**Table 1 Response to Agency Submissions**

Appendix C. Swept path analysis at The Crescent / James Craig Road

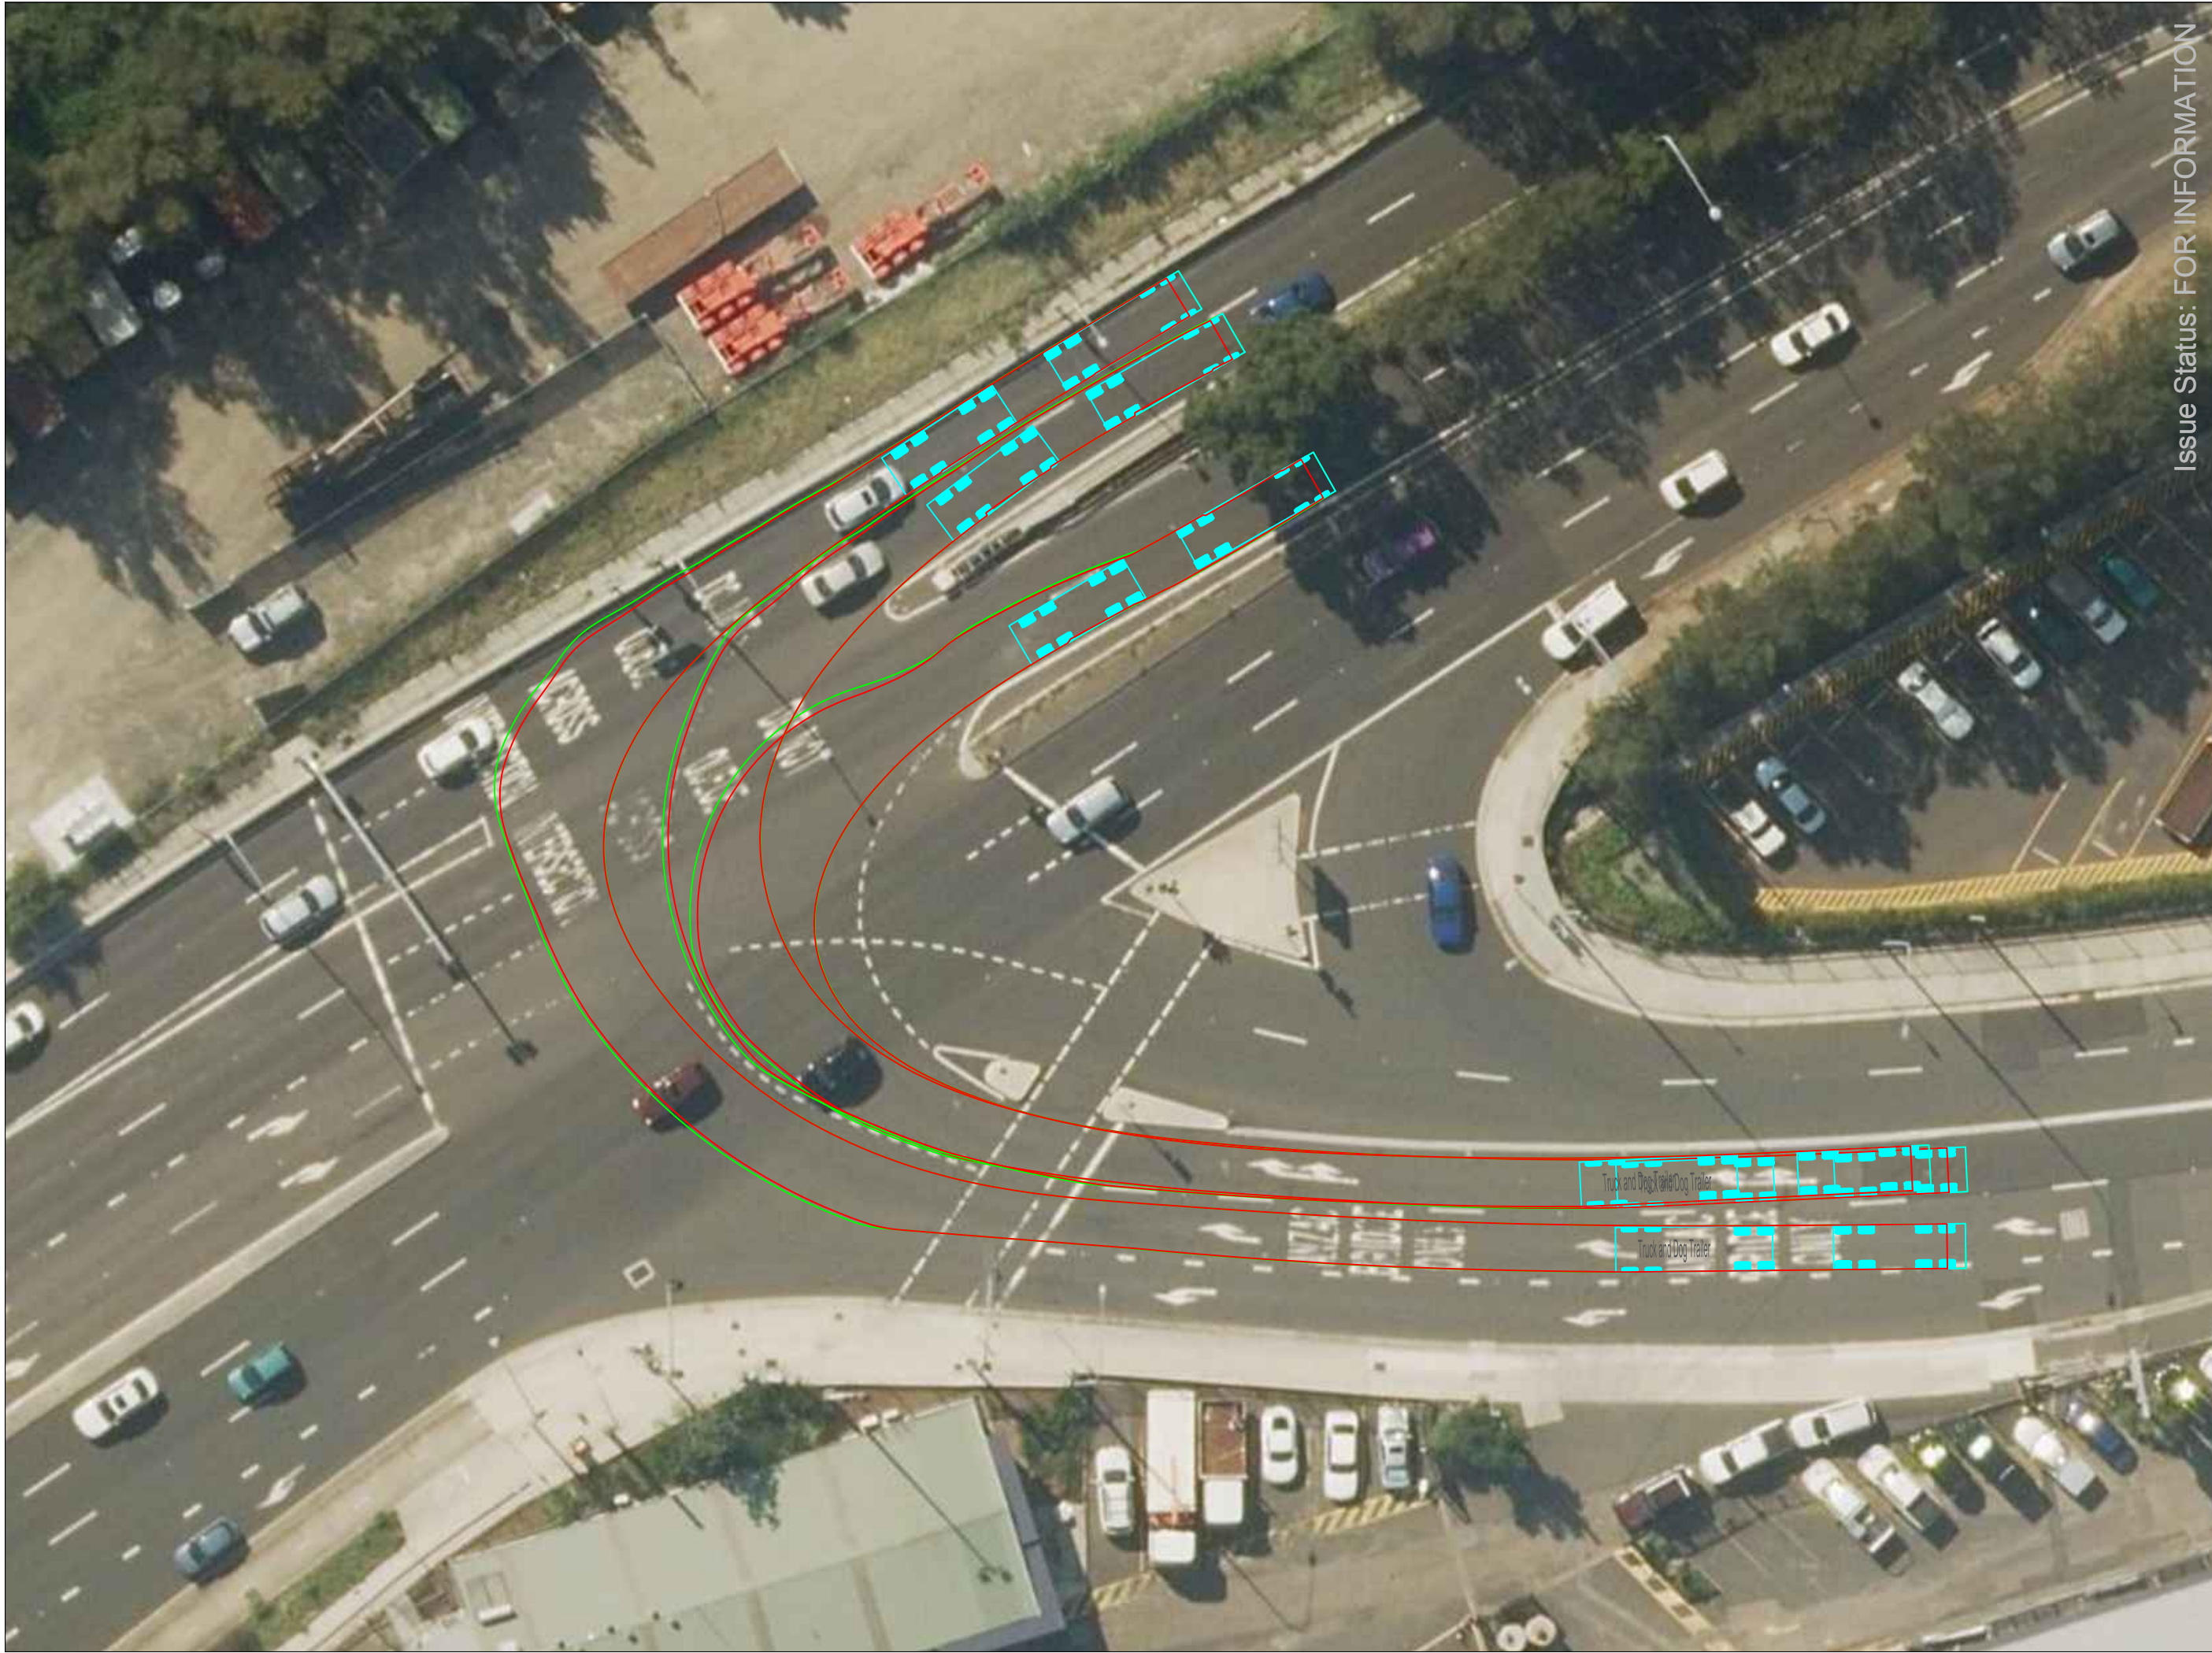
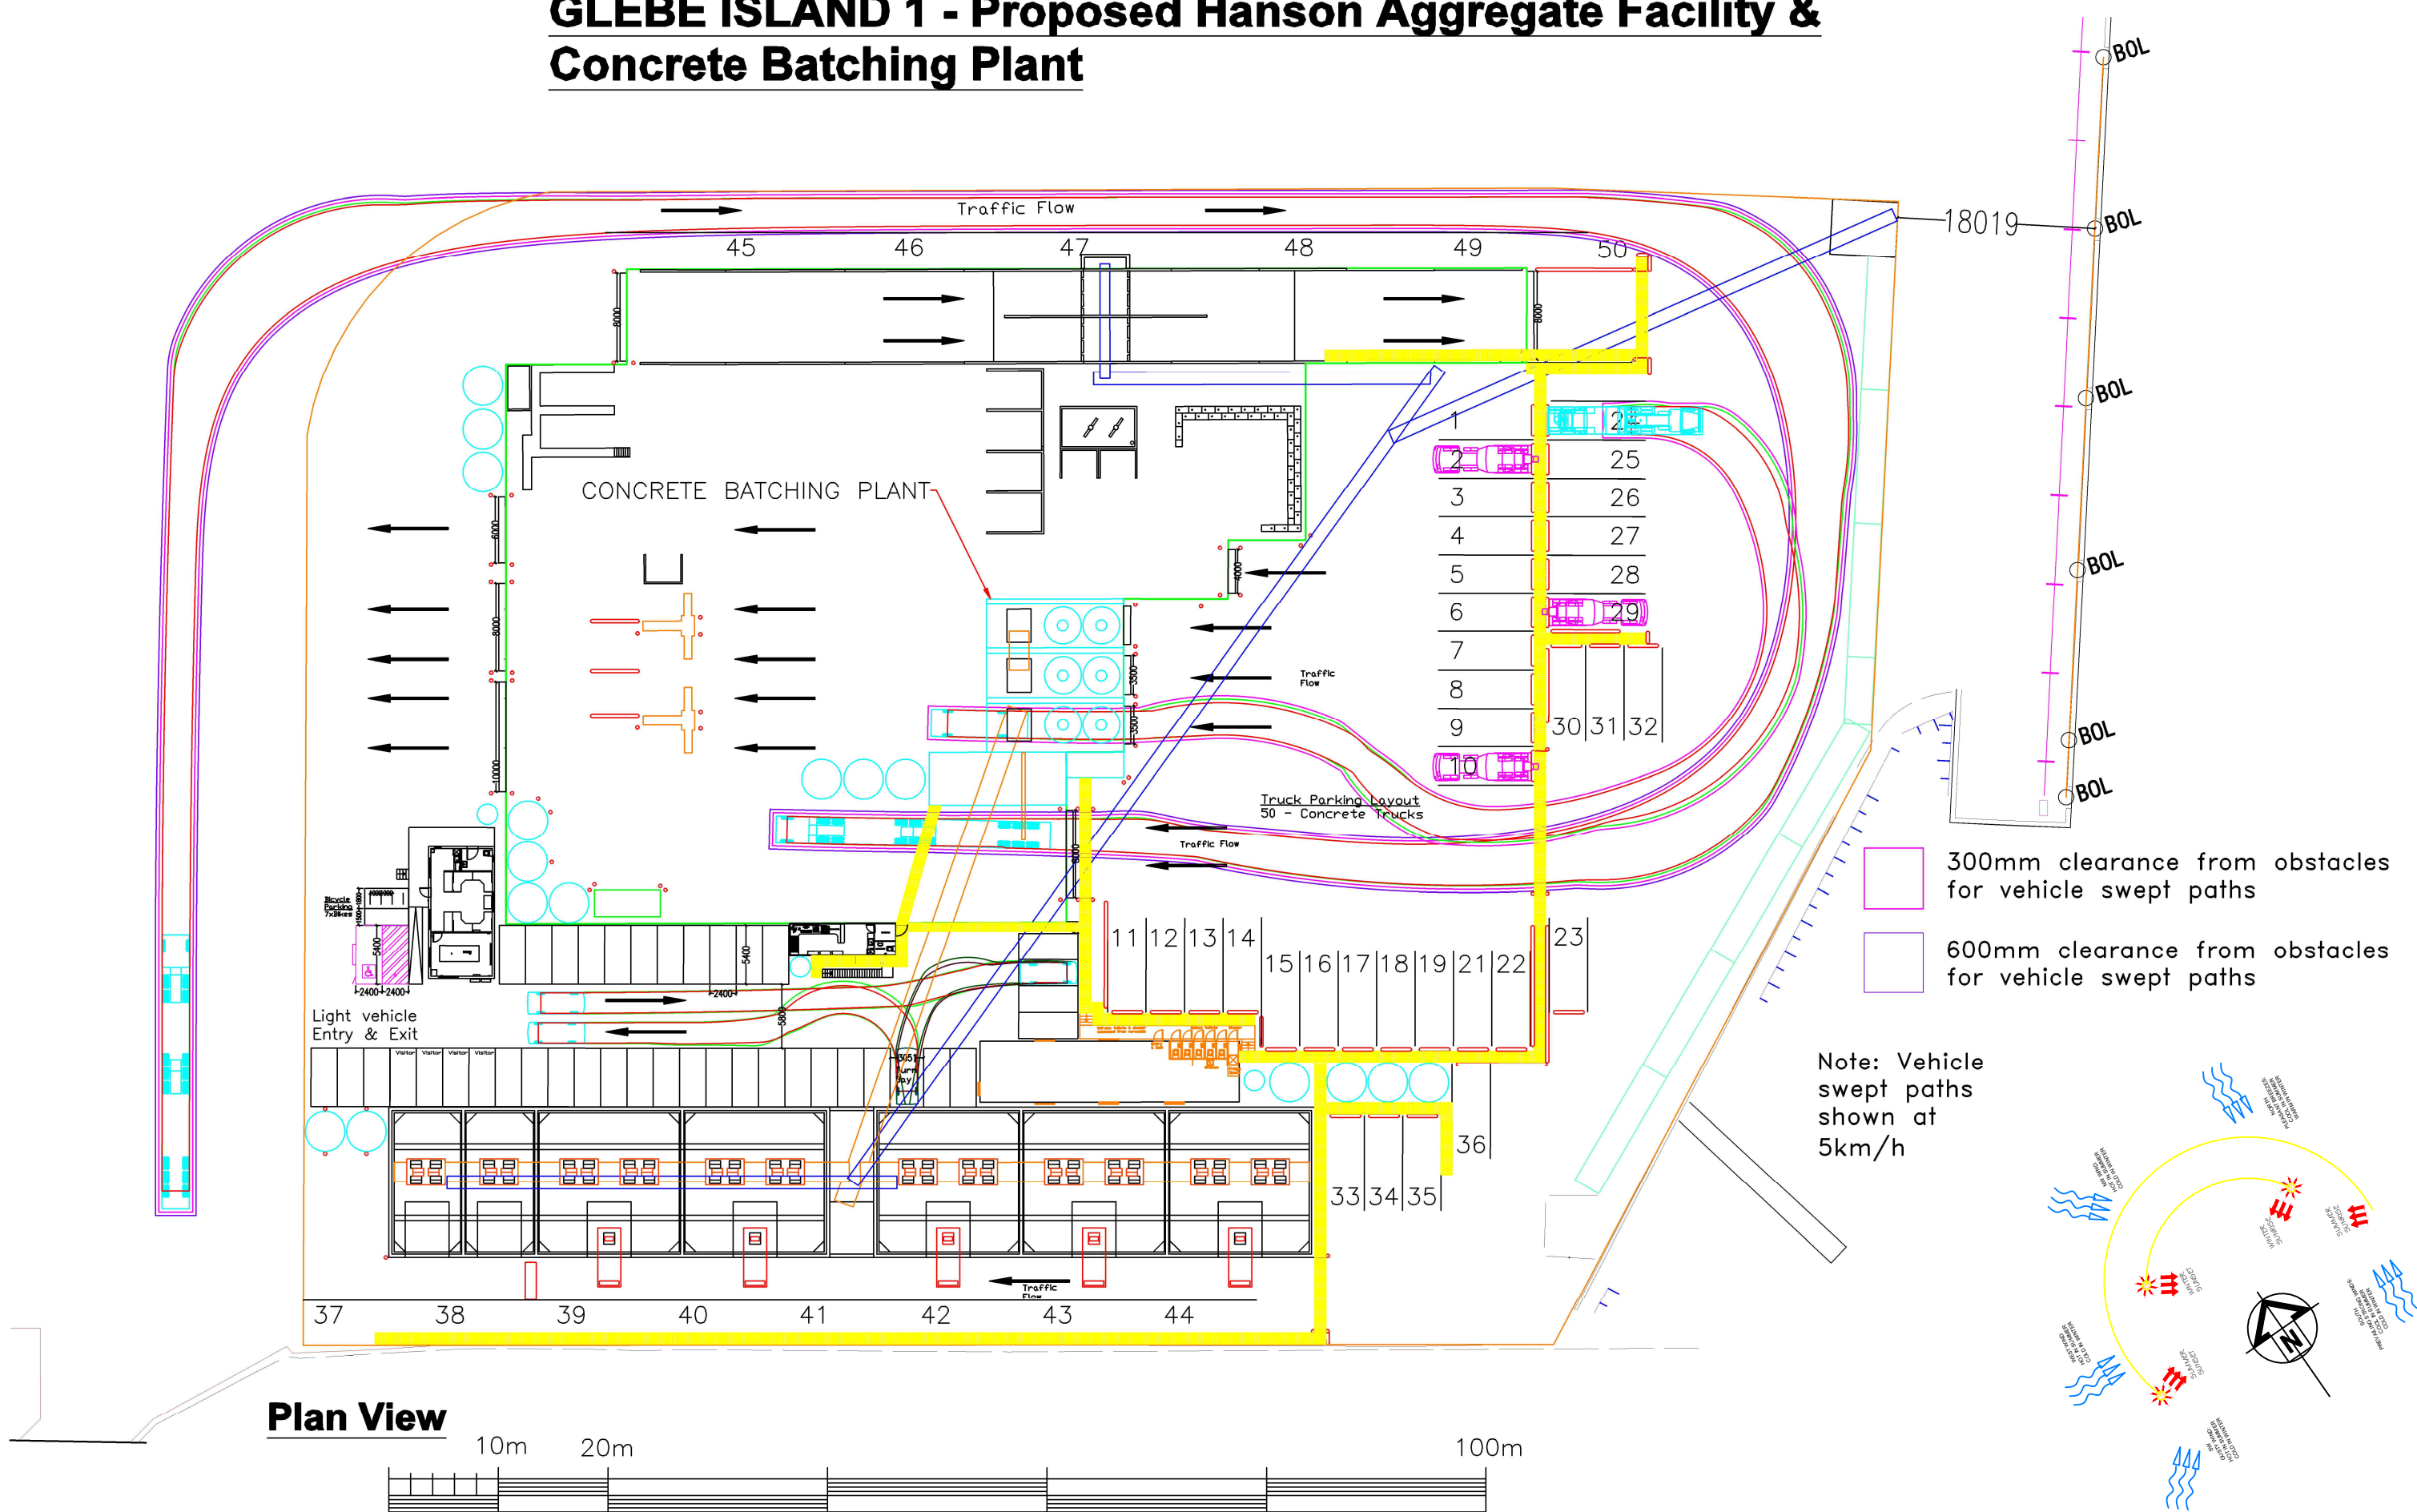
<b>Roads &amp; Maritime Services (RMS)</b>		
<b>Traffic – Right Turn at The Crescent / James Craig Road Intersection.</b>	RMS is concerned that additional large trucks will reduce the ability for two vehicles to turn side-by-side at the intersection of The Crescent / James Craig Road, leading to a reduction in capacity of the right turn movement beyond that envisaged. Additional information is requested to be provided on whether the traffic capacity of the right turn is likely to reduce based on a swept path assessment of right turning Cement, Aggregate and Concrete trucks and if so, this is to be reflected in the traffic modelling.	Refer to Supplementary Traffic Report in <b>Appendix E</b> .
<b>Traffic – M4-M5 link.</b>	The traffic impact assessment prepared by the Applicant notes that the M4-M5 link is likely to reduce traffic volumes on City West Link in the vicinity of the site. While this is accepted, the project is likely to be completed in 2023. The M4 East project is expected to be completed in 2019 and RMS request additional information on the impact of the intersections in the vicinity of the site considering the likely timing and opening date of the project.	Refer to Supplementary Traffic Report in <b>Appendix E</b> .
